Subject: A/55/19/PL

With regard to the application I would like to make two observations aimed at avoiding irreversible mistakes and damage to protected Local Green Space.

Site Plan (1:200)

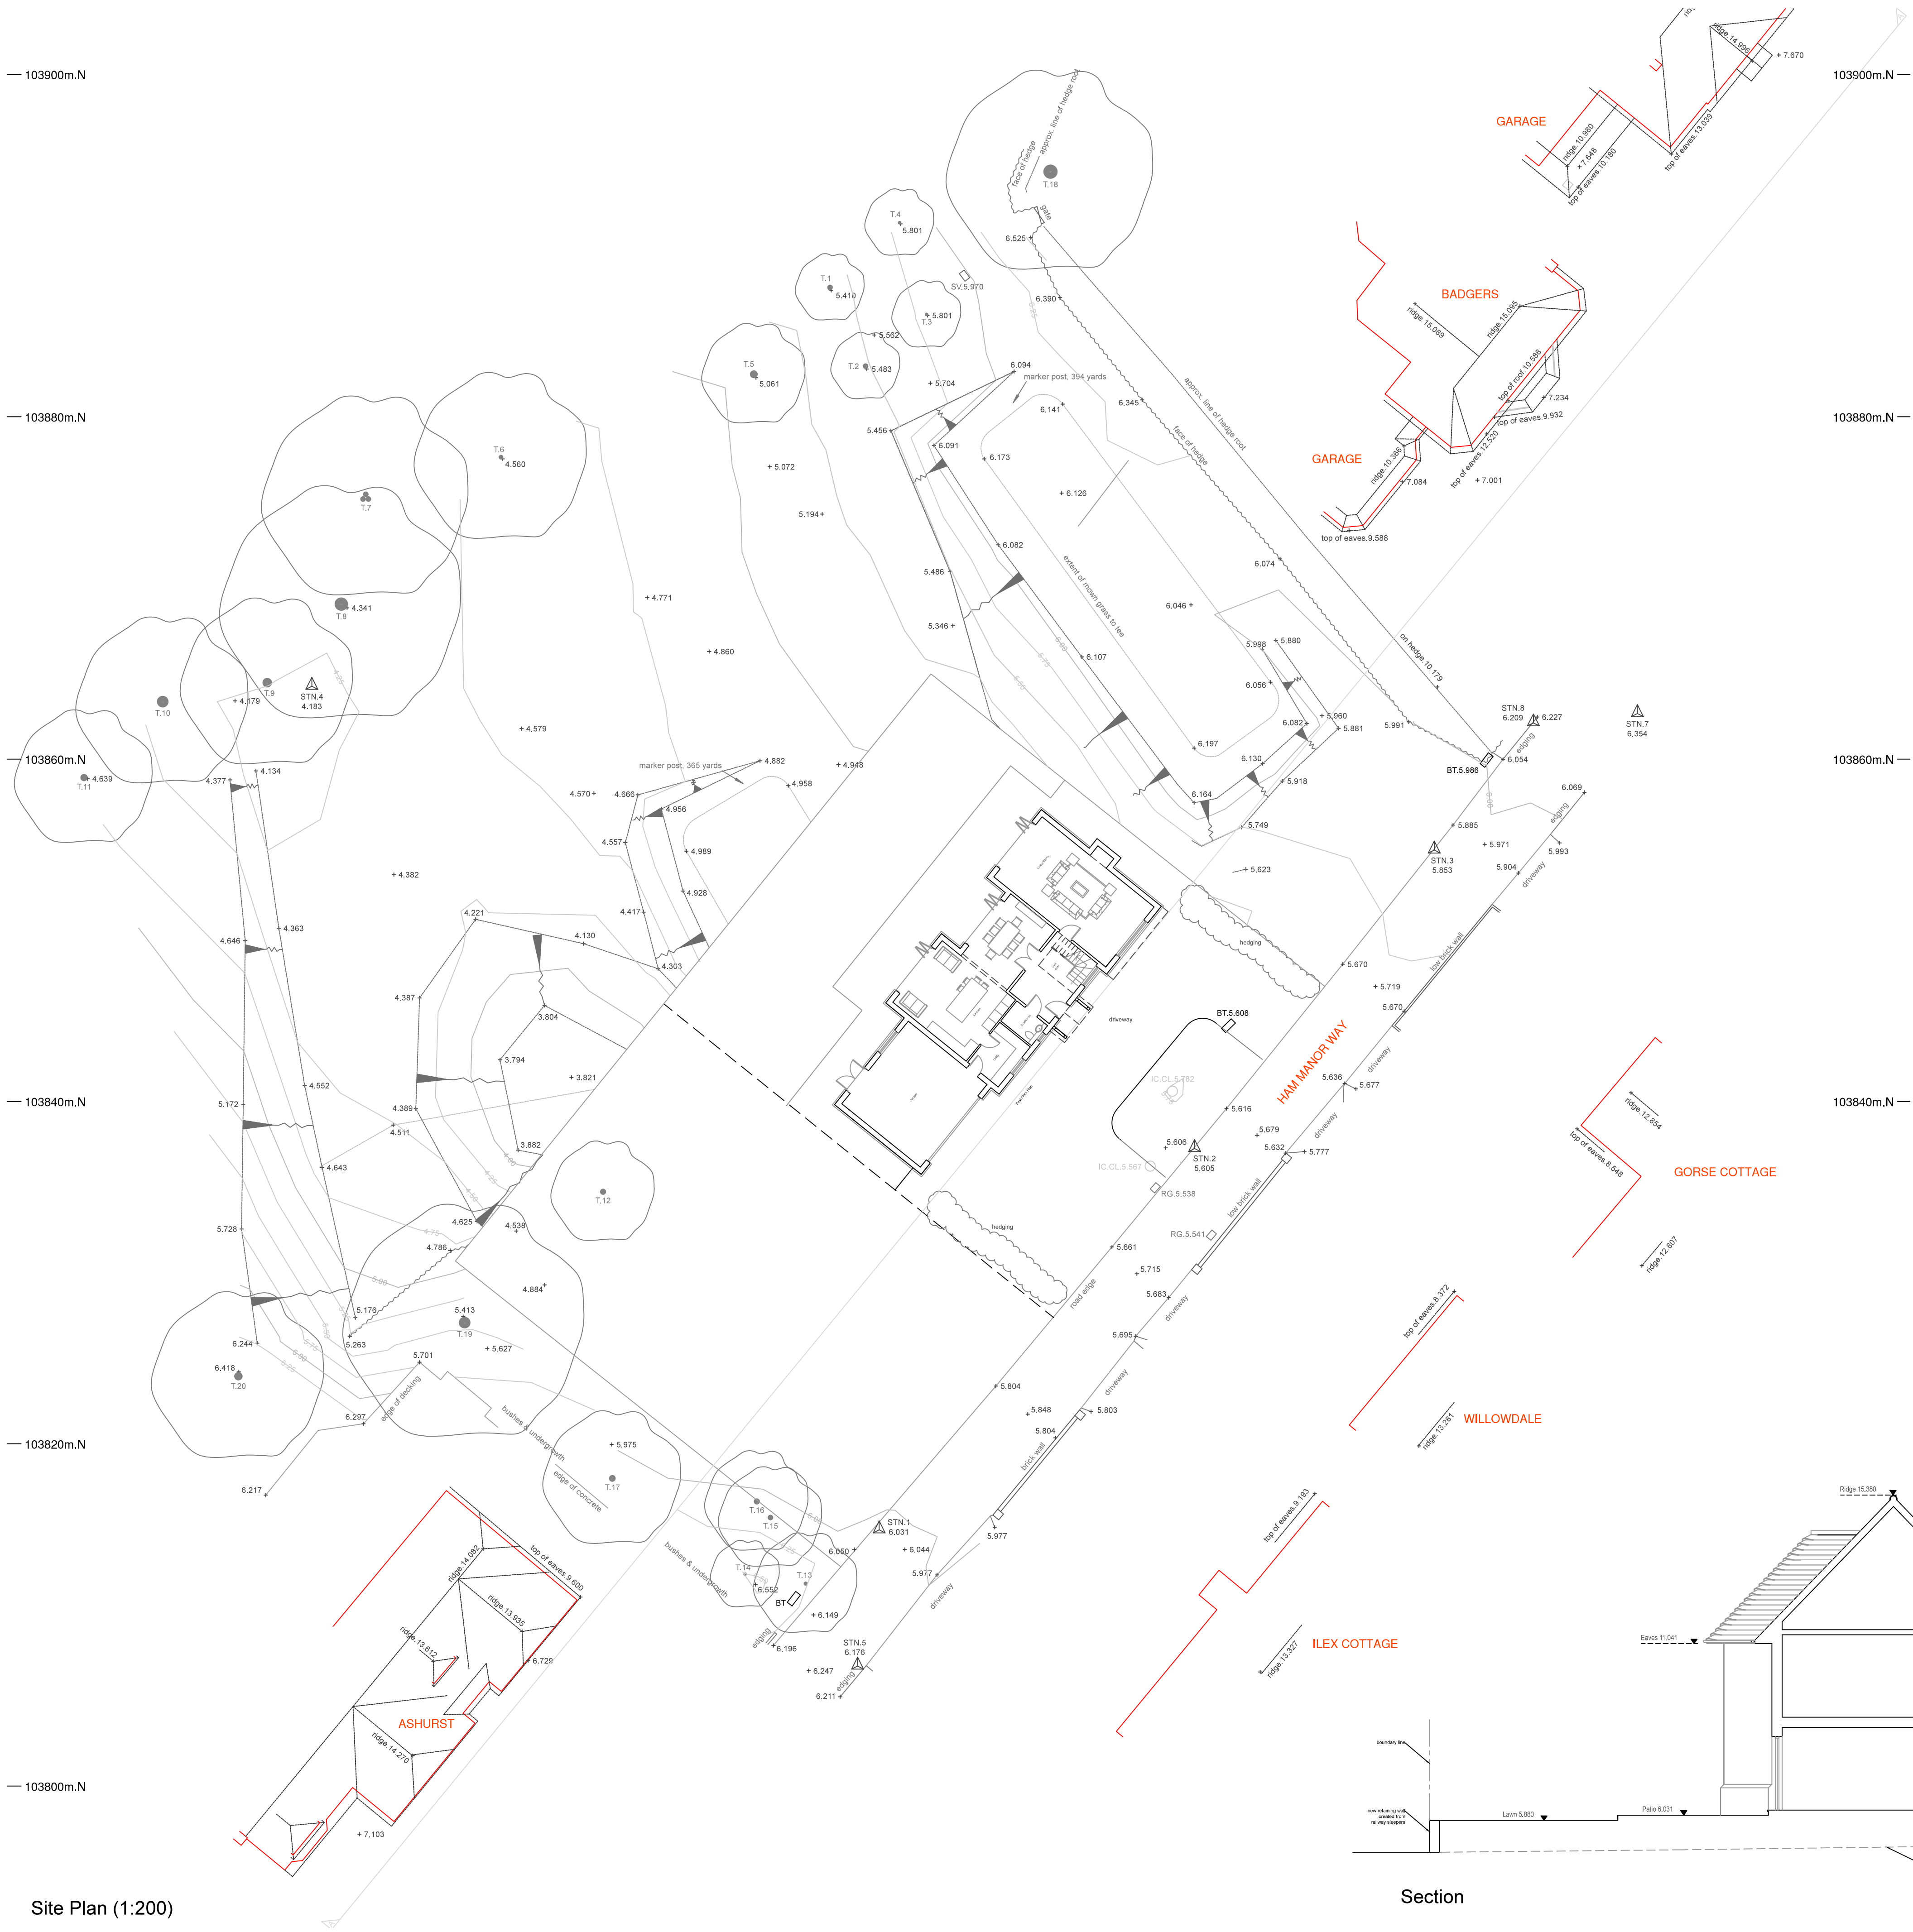
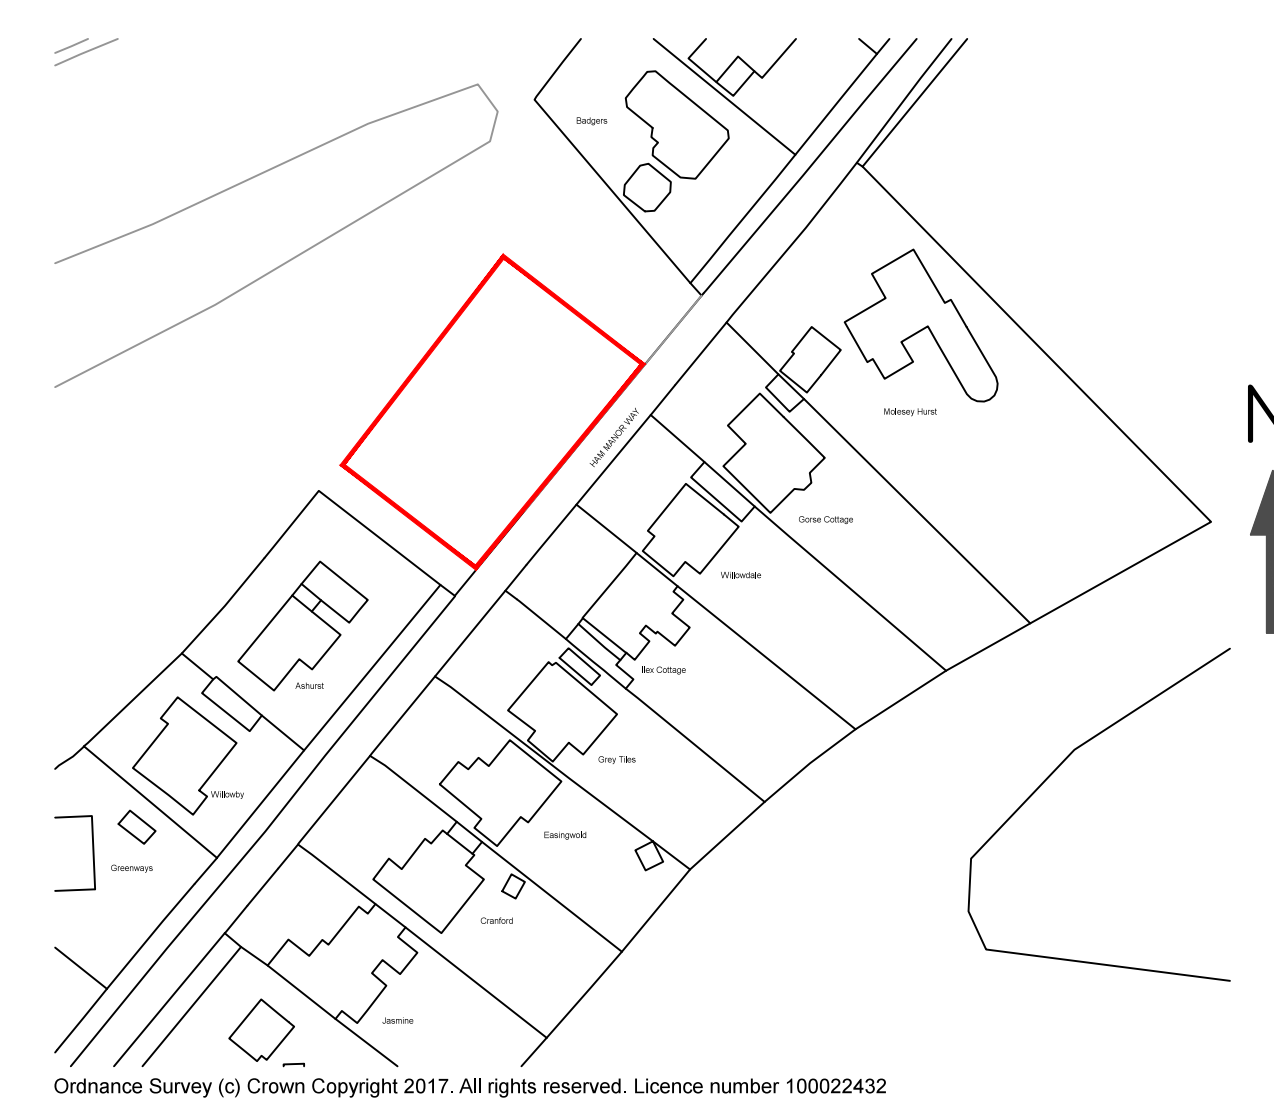
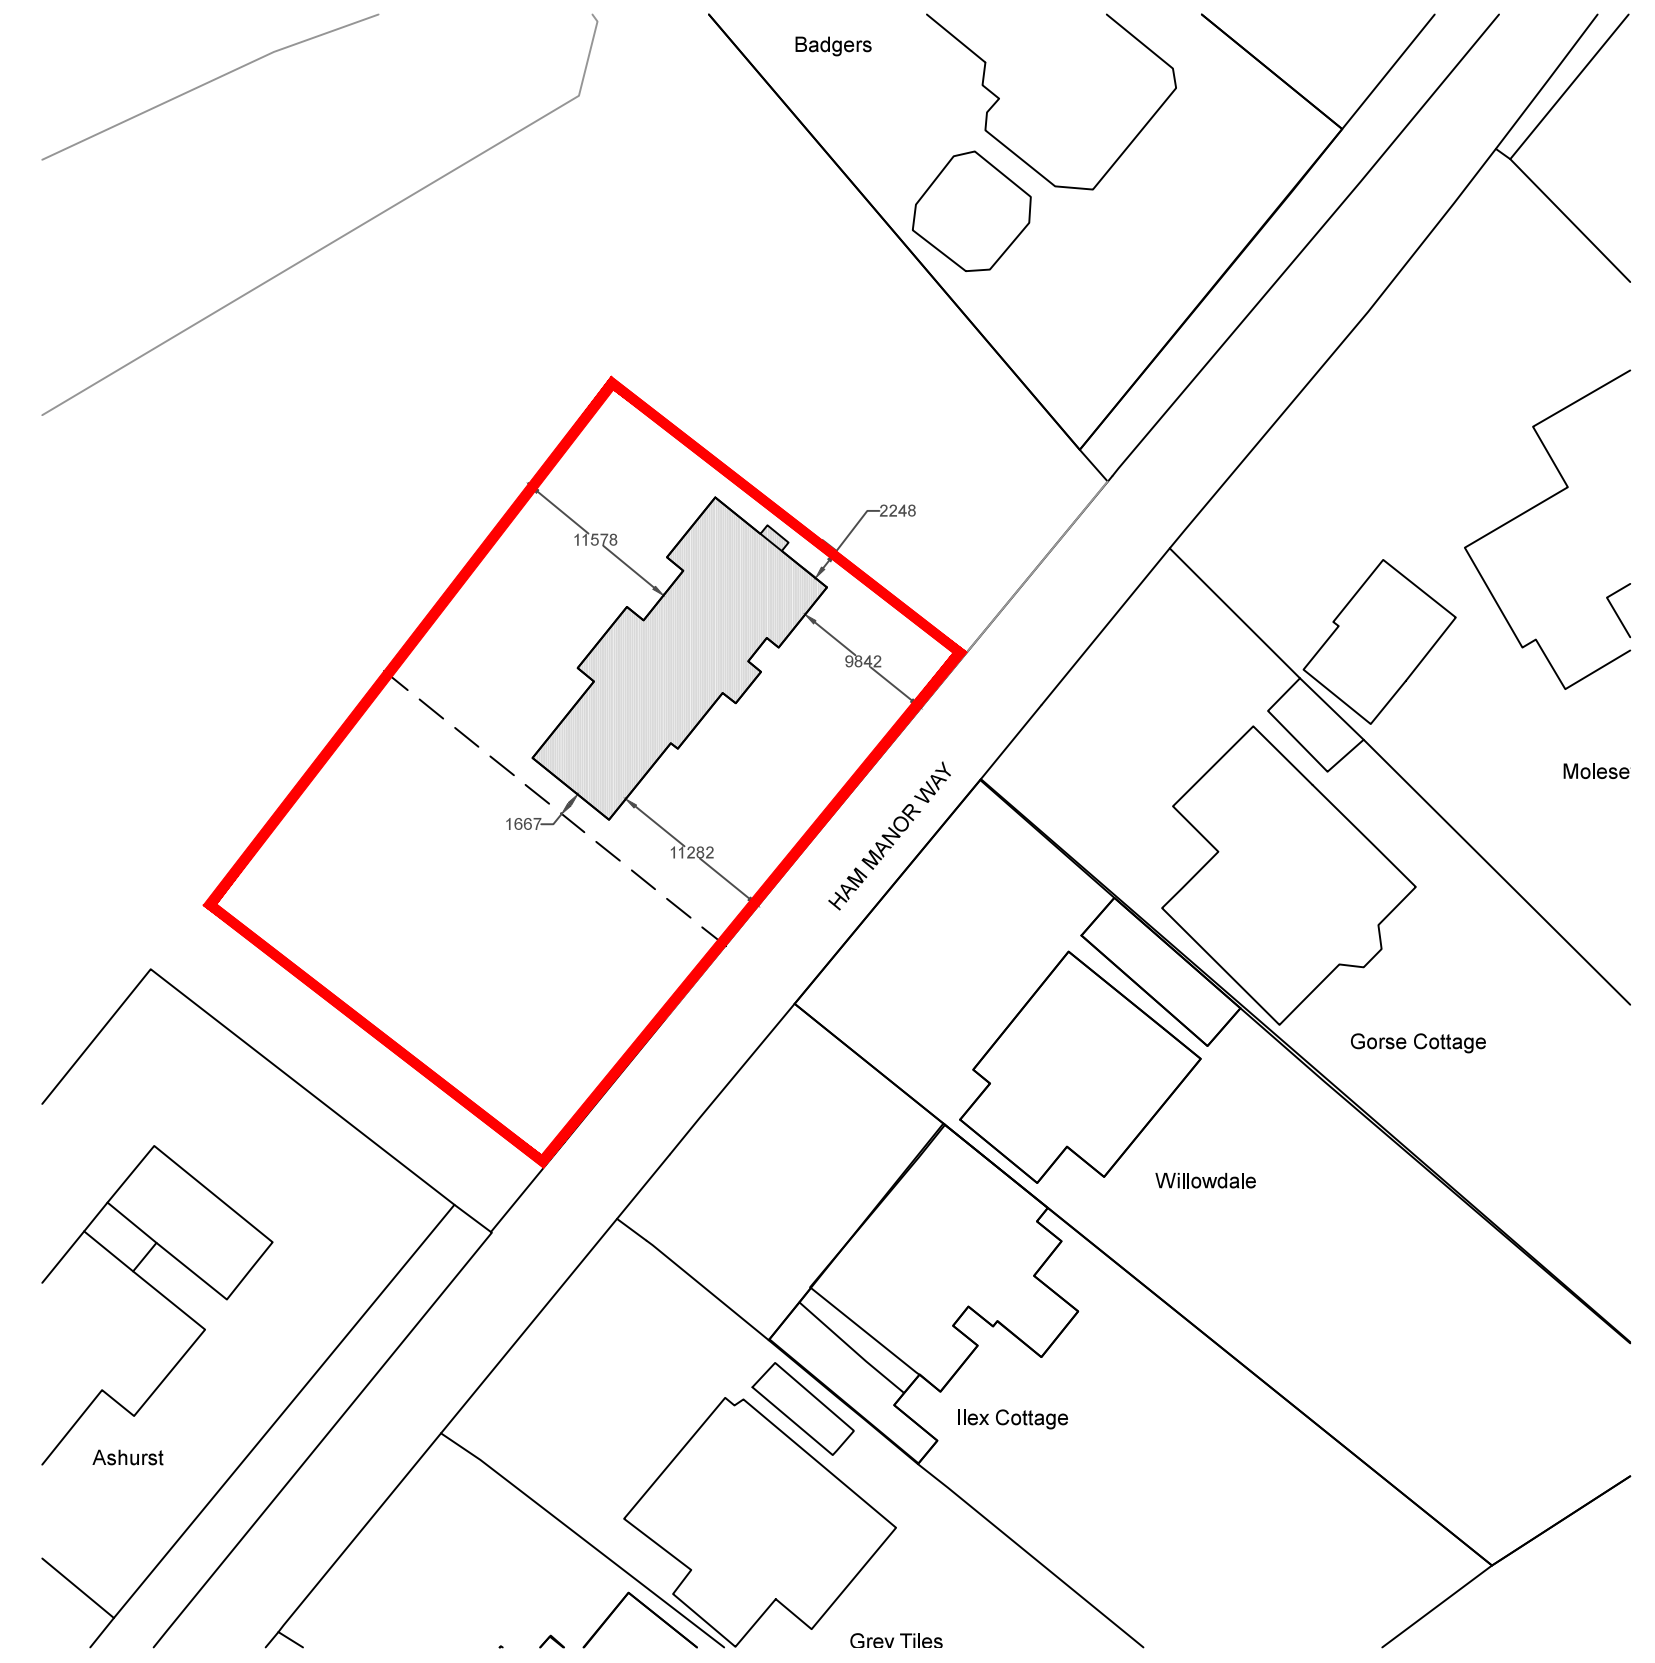
- a). The size and shape of the red outlined plot in A/55/19/PL does not match with a number of plans indicating where any extant plots may exist and in it's present form the application will compromise Protected Local Green Space/Green Belt as well as being outside the BUAB.
- b). The property described is the same property as in A/31/19/PL which was refused under policy HD5. Logically it should follow that A/55/19/PL should be similarly refused.

The plans show the North edge of plot 6 being some 24m deep with plot 7 narrowing to some 21m deep. This carries on with plot 9 narrowing to some 13m at the furthest edge North.

All this is then in great conflict with A/55/19/PL showing it's "red rectangle" being some 29m deep along it's entire length.

A/115/16/HH shows Ashurst, plot 6 and incorporating part of plot 7, squared off but whether this was by design or accident when initially done it does not form a precedent for the plots beyond Ashurst. No boundary dimensions are shown but using Ashurst's present rear boundary as a possible starting point for any extant plots would be a false starting point.

As an additional reference I would refer you to the Adopted Arun Local Development Plan and Local Plan Policy Map 4. Map 4 clearly shows the rear boundaries of Ashurst and its neighbour narrowing down. Outside of the boundaries is Local Green Space and if the plots claimed in A/55/19/PL as part of the extant permission are allowed they will clearly be affecting Local Green Space, as also identified in the "made" ANDP as HMGC. The questionable part of the "red rectangle" of A/55/19/PL is a "triangle" from the SouthWestern end broadening to the NorthWestern end of the area which looks as if it should be protected Local Green Space. It is also the outside of the BUAB.
